Your ref: SSD-9368
File no: MC-19-00004

SSD-9368 – Modification 4 to Alex Avenue Public School – 95 Farmland Drive, Schofields (Lot 2 DP 1244925) and Part Lot 1 DP1244925

Blacktown Council's submission to SSD 9368 – Modification 4 to Alex Avenue Public School at 95 Farmland Drive, Schofields

Figure 2 Temporary on-site school carpark

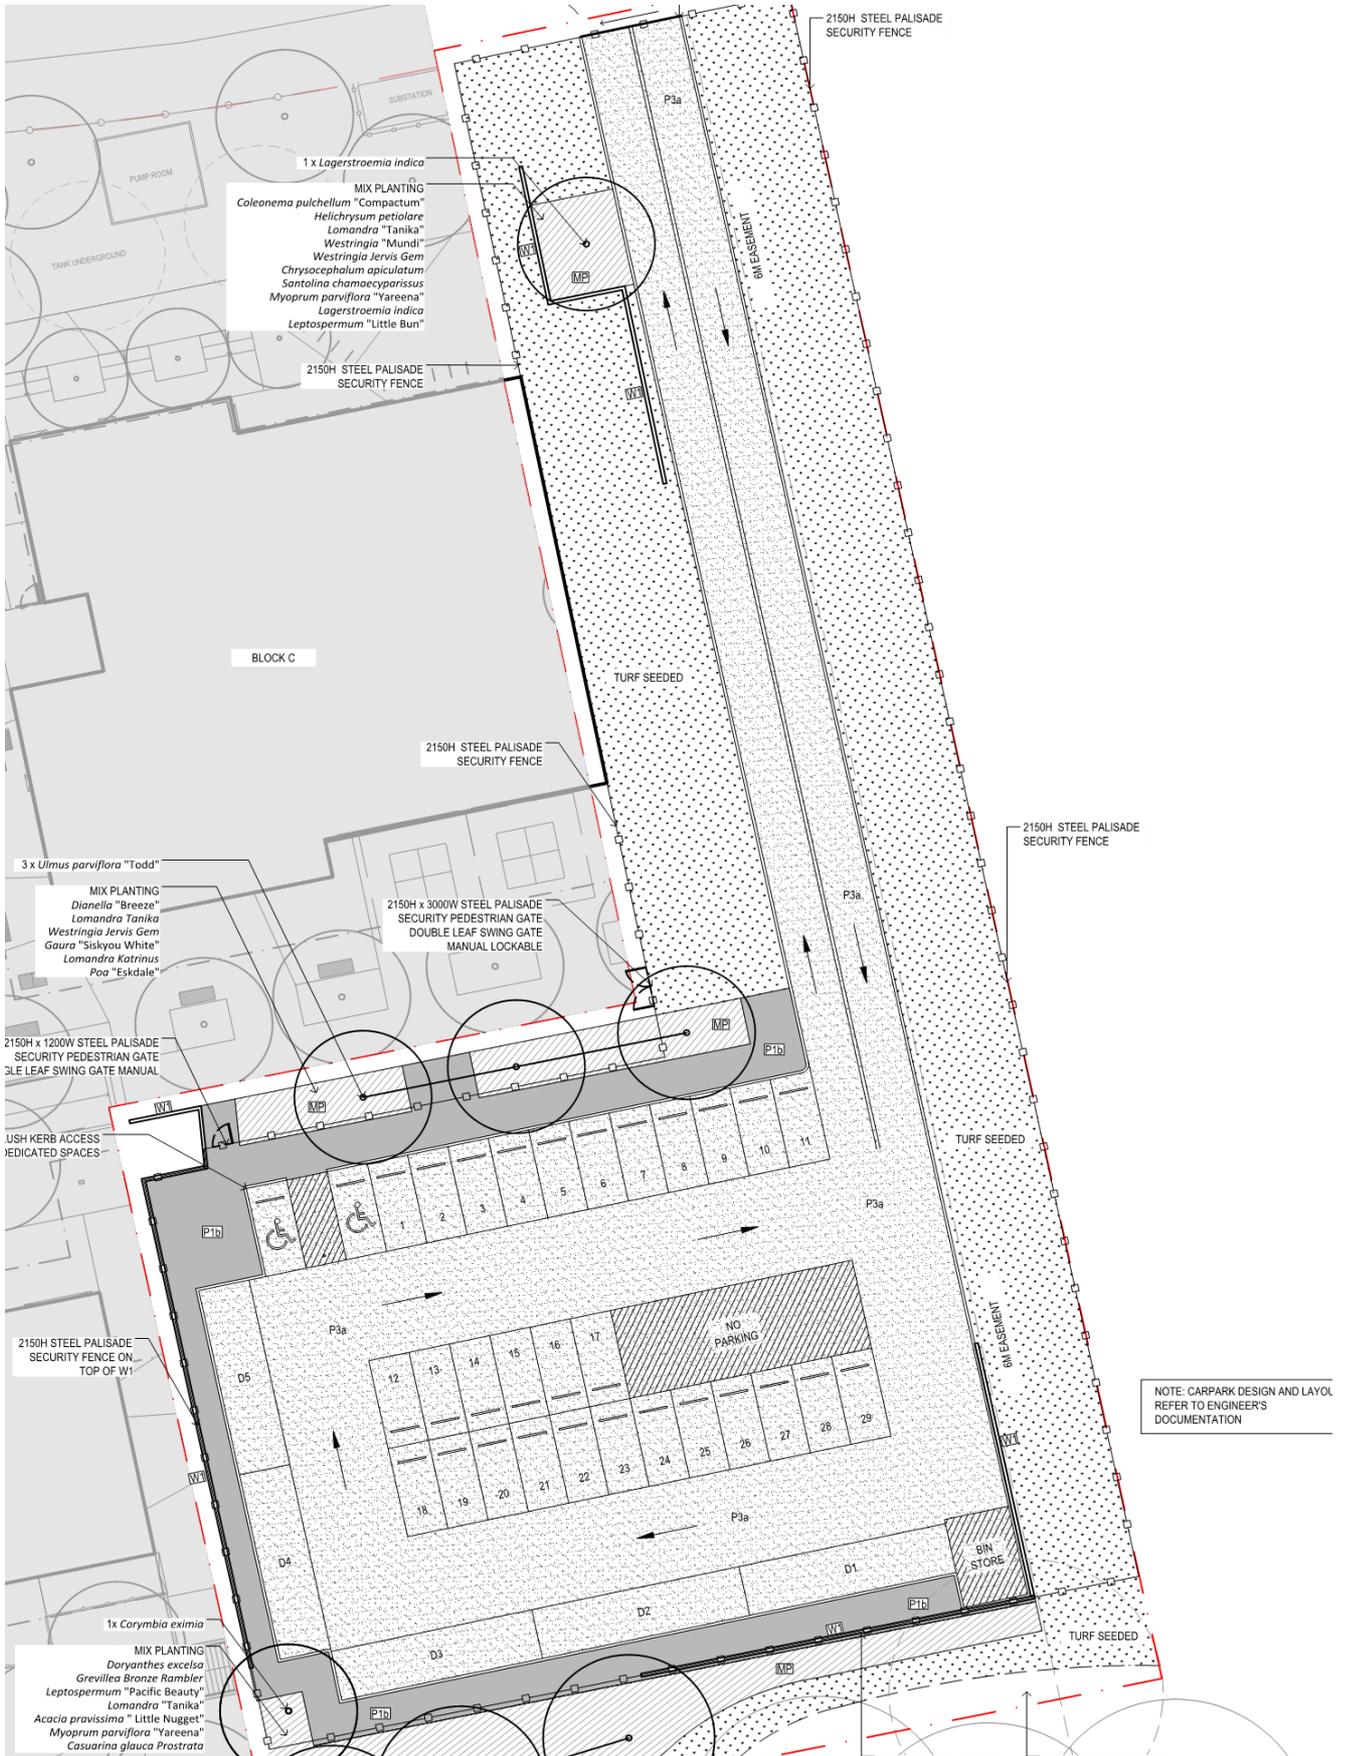
- a. Insufficient information has been provided regarding Appendix C: Easement Management Plan. Recreation Planning Design Section is seeking clarification regarding the following: -
 - o Detail the specific works to be completed in Easement A and a timeframe for completion.
 - o The temporary car park is noted as being required for access to construct Stage 2 as per Figure 10 Page 12. The applicant is to clarify if this means that all Easement A works will not be completed until the completion of the Stage 2 works. More information is required on this matter.
